Subject: R-6 Small Infill Design Review – 44 Quebec Street

Written by: Caitlin Cameron, Urban Designer

Date of Review: Wednesday, April 19, 2017

DRAWN BY EMW
SHEET TITLE ELEVATIONS

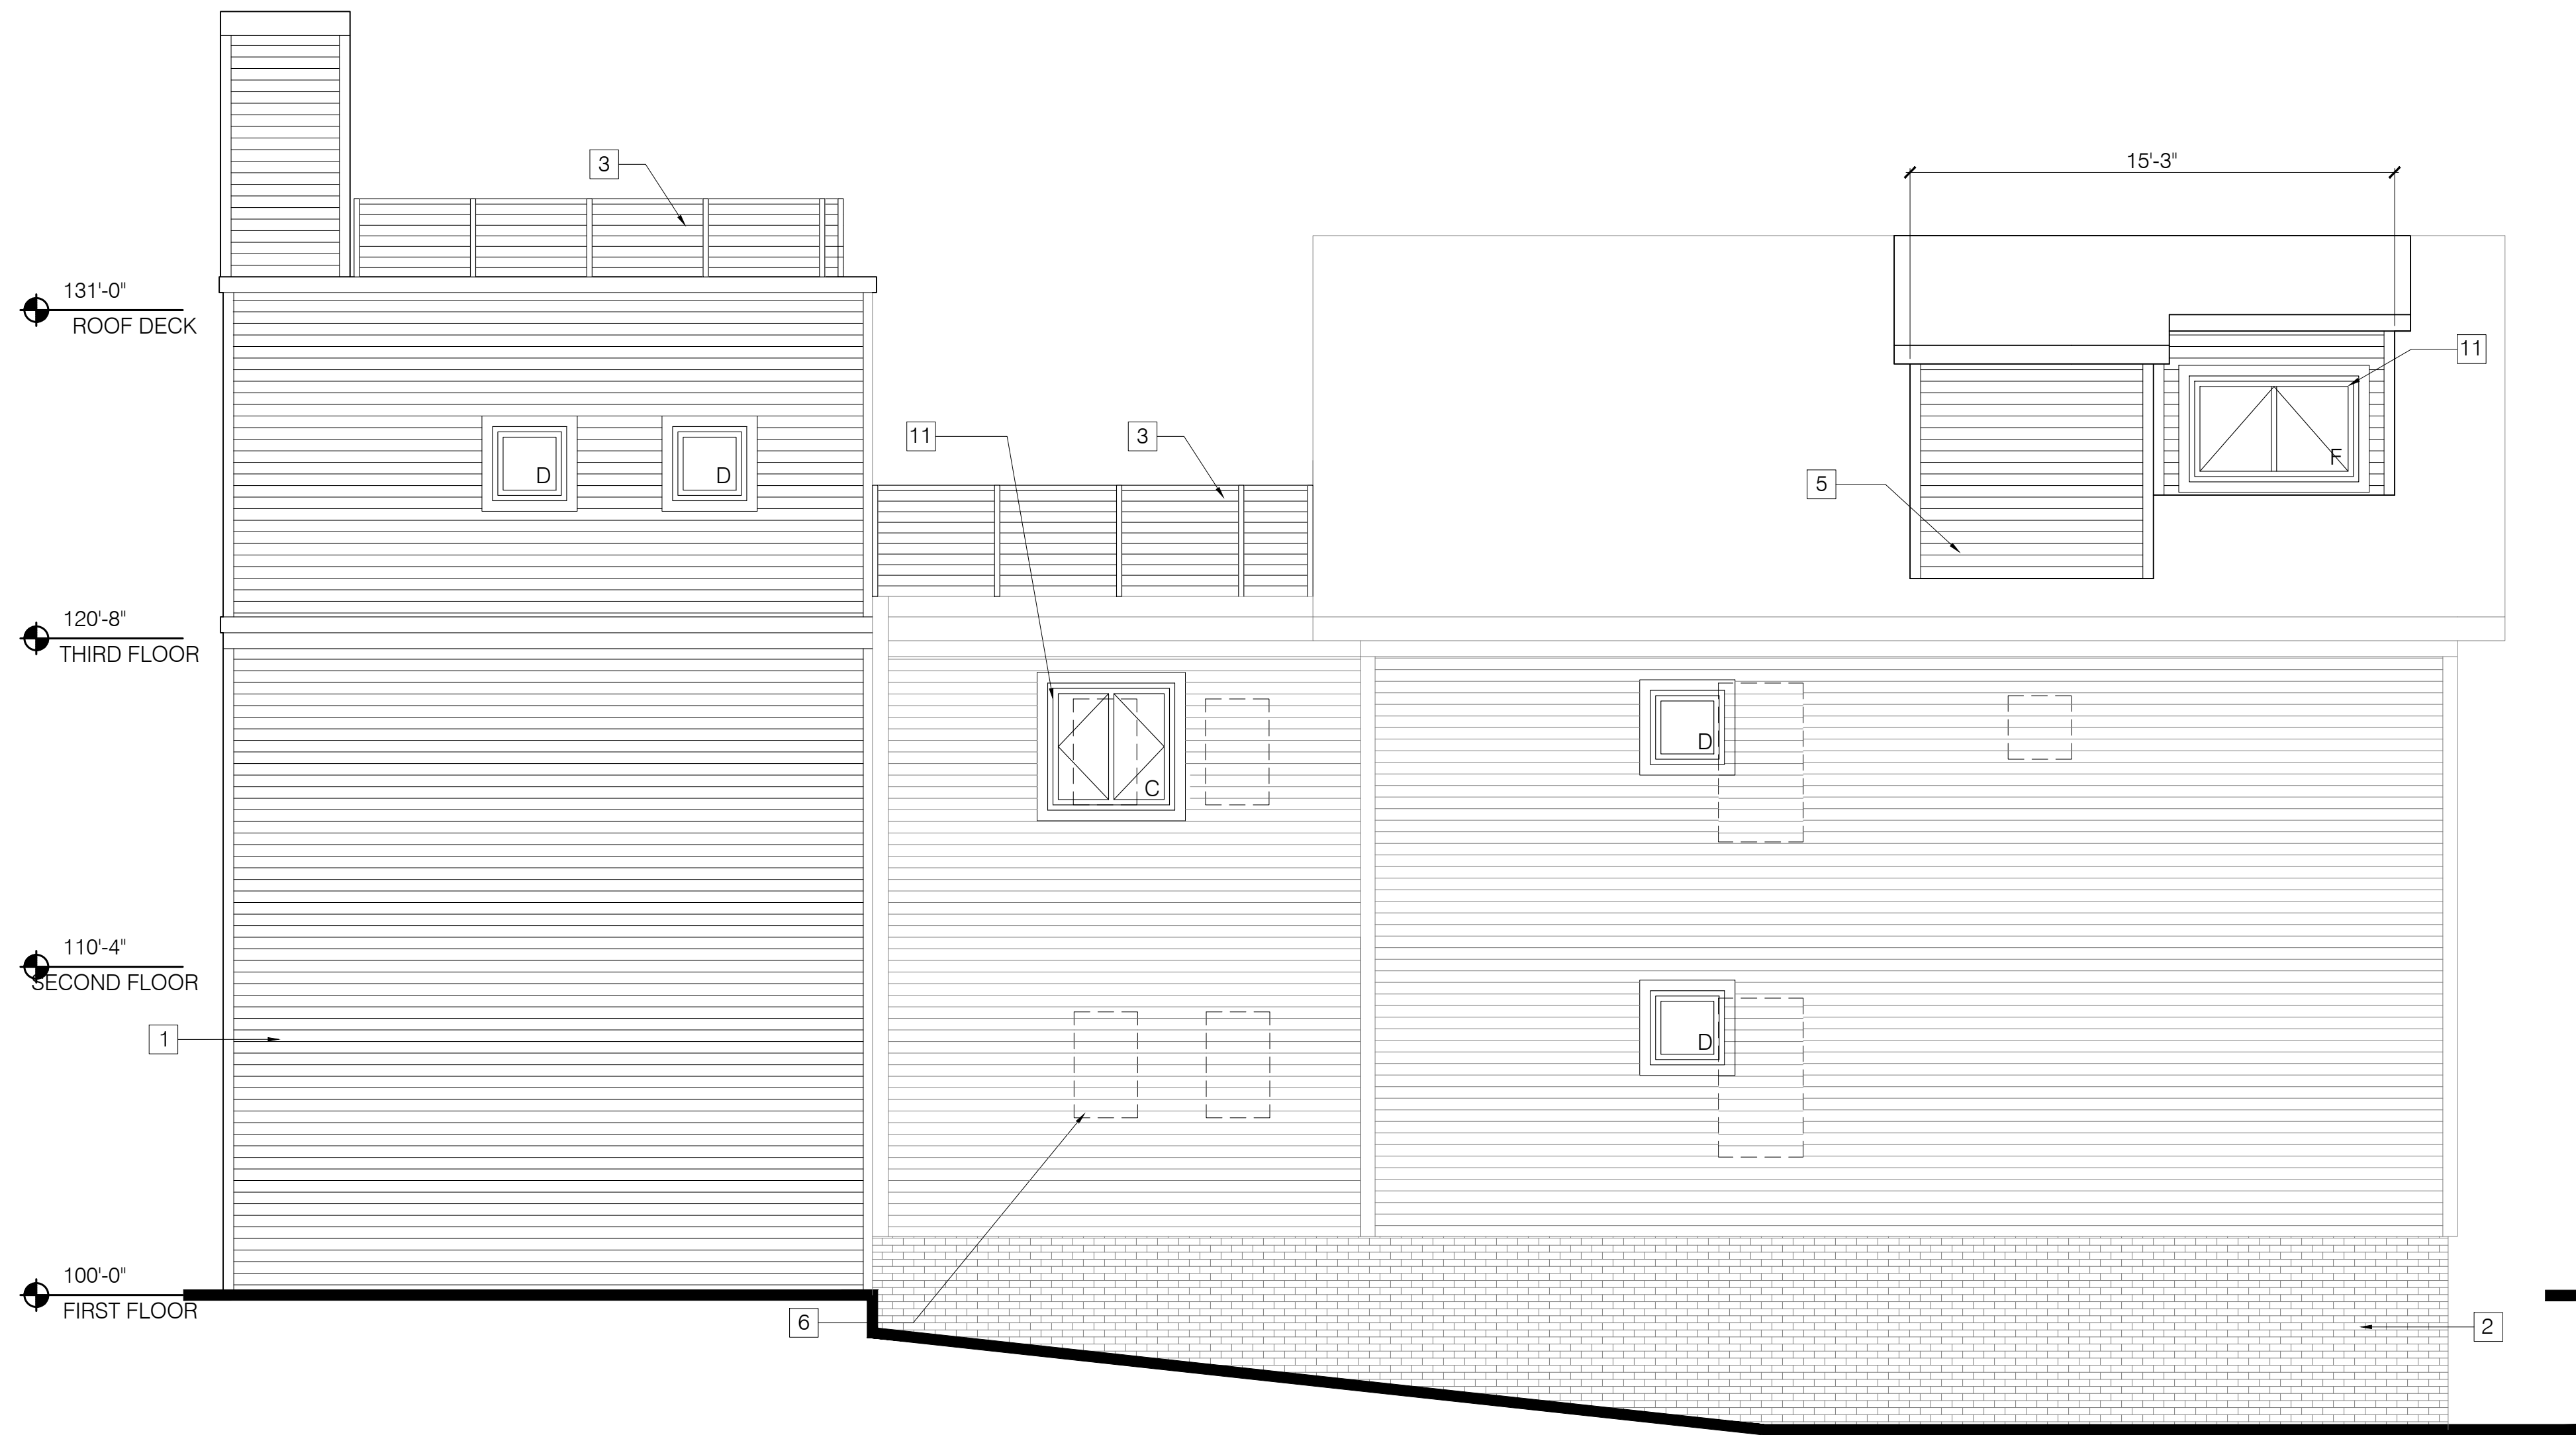
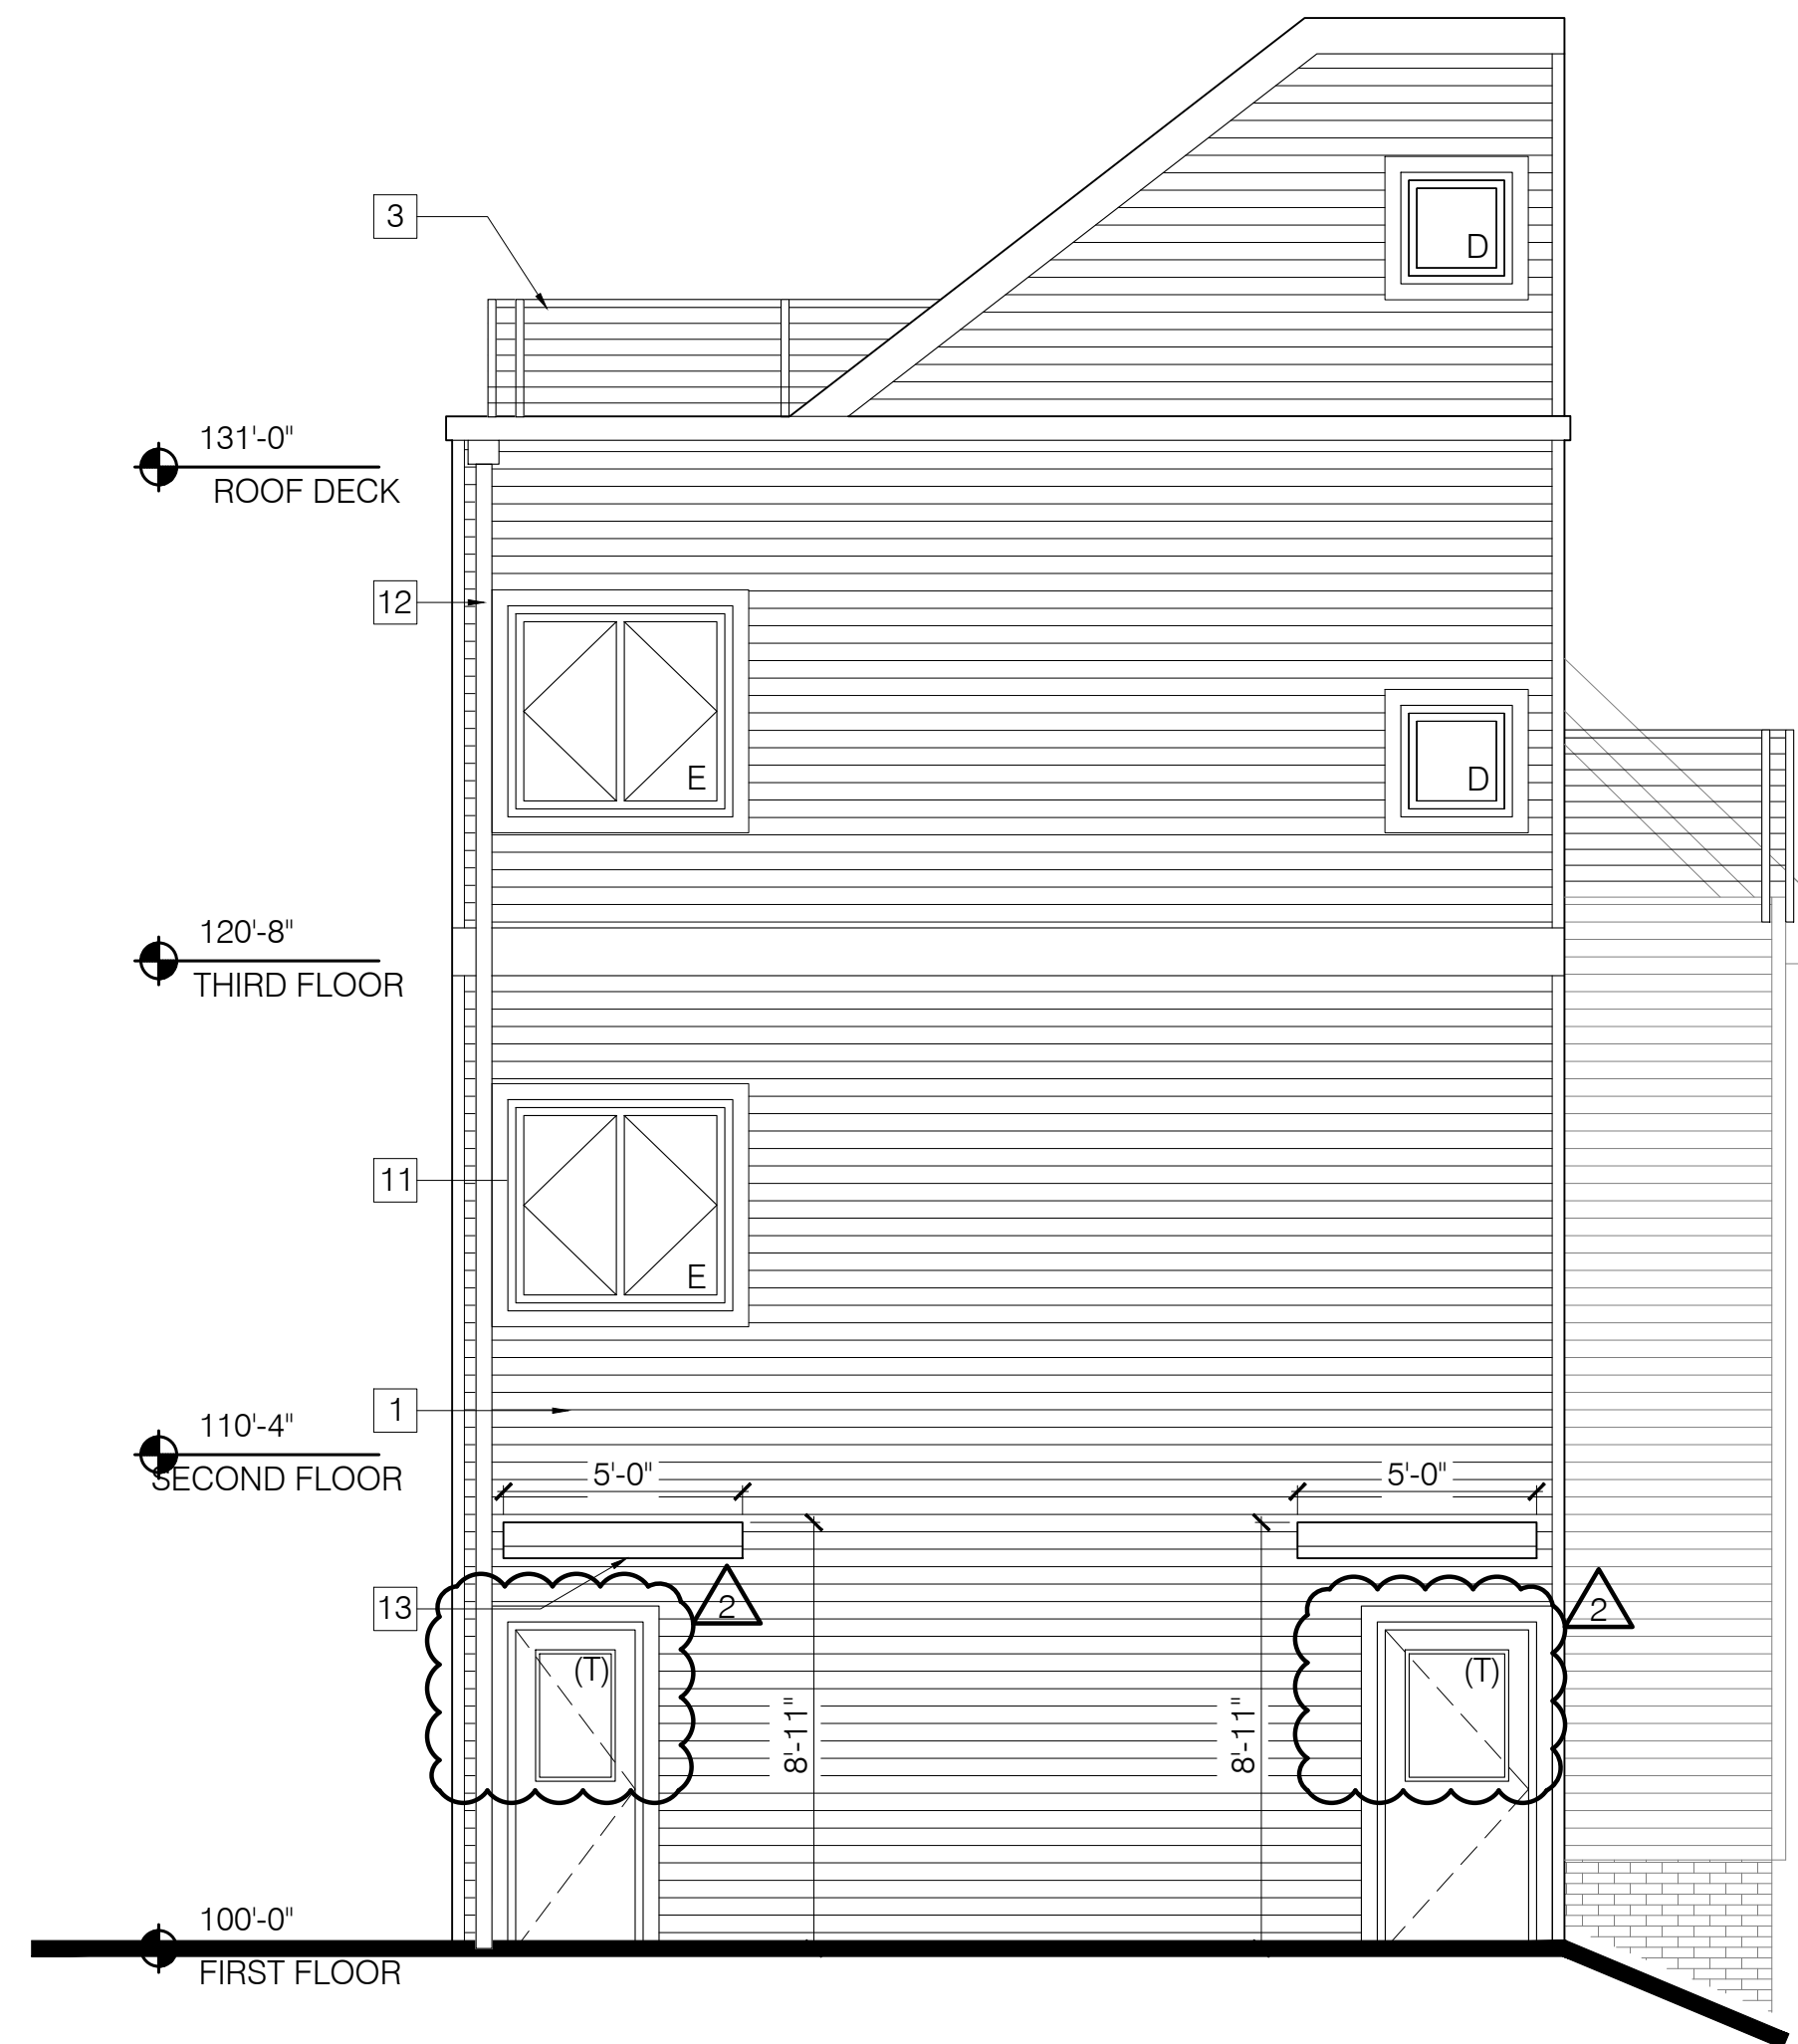
- *A-1 Scale and Form:* The building is a hybrid of existing front-end gable single family home with a contemporary simple, flat-roofed unit. The massing and scale of the contemporary addition is mitigated through a couple strategies – the roofline is below the ridge of main roof form, the second story line is reinforced throughout the side elevation with trim details, the original roof deck railing has been setback and lowered.

- *A-2 Composition of Principal Facades:* The composition of the Quebec street-facing facades is consistent with context in terms of using symmetrical bays (two or three bays) that are oriented to the street. The window placement throughout the project is symmetrical and simple, similar to the context. The window proportion was revised to be more similar in proportion to what is found in context. The new construction has a vertical proportion and is symmetrical in composition. Some articulation elements such as trim and railings are added.

- *B-1 Massing:* The principal mass is an existing single-family home. The new addition is a more contemporary and bulkier massing appended to the existing form. The proposed new construction has a vertical proportion and a flat roof. The roof deck detailing was revised to reduce the perceived height of the new addition. A trim detail at the second floor helps visually break the three story box.

- *B-2 Roof Forms:* Multiple roof lines – flat and gabled with dormer are found in the context.
- *B-3 Main Roofs and Subsidiary Roofs:* On Quebec Street, the main roof form is the front end gable. The new dormers are pulled back from the Quebec building face keeping the gable as the dominant roof form on that façade. On Howard Street, the existing condition is already quite complex in massing and roof forms. The new addition has a flat roof line that is slightly lower than the original building roof ridge line.

Principle D Proportion and Scale – Staff recommends that the original house maintain a traditional vertical proportion window to keep the integrity of the original façade composition and to be contextual with the surrounding context – this is especially important on the Quebec Street façade which is now losing its entrance and canopy details. The new addition could have a different window type or proportion – continuity of fenestration between new and existing is not critical.

- *D-1 Windows:* The majority of windows are rectangular and individually have vertical proportions. Windows were revised to be more vertical on all elevations in the original portion of the building to better reflect the context. The new addition has shorter windows to set it apart as a contemporary addition.
- *D-2 Fenestration:* It appears the 12% fenestration requirement is met on both street-facing facades.
- *D-3 Porches:* The porch meets the dimensional requirements. According to zoning, the front façade faces Quebec Street and so the porch does not need to meet the 20% requirement as stated in this standard.

- *F-1 Articulation:* Windows have trim, corner trim boards, clapboard siding, trim at second floor. Some articulation will be provided by the railings, roof overhangs, existing cornice lines. Some articulation is lost with the removal of the entrance canopy.

- *F-4 Delineation between Floors:* The floors are delineated by fenestration patterns, roof lines.
- *F-5 Porches, etc.:* The existing entrance and canopy are being removed. The side entry includes a recessed porch (existing) to become the main entry, the porch will be reduced from original size. Why no railing on porch?
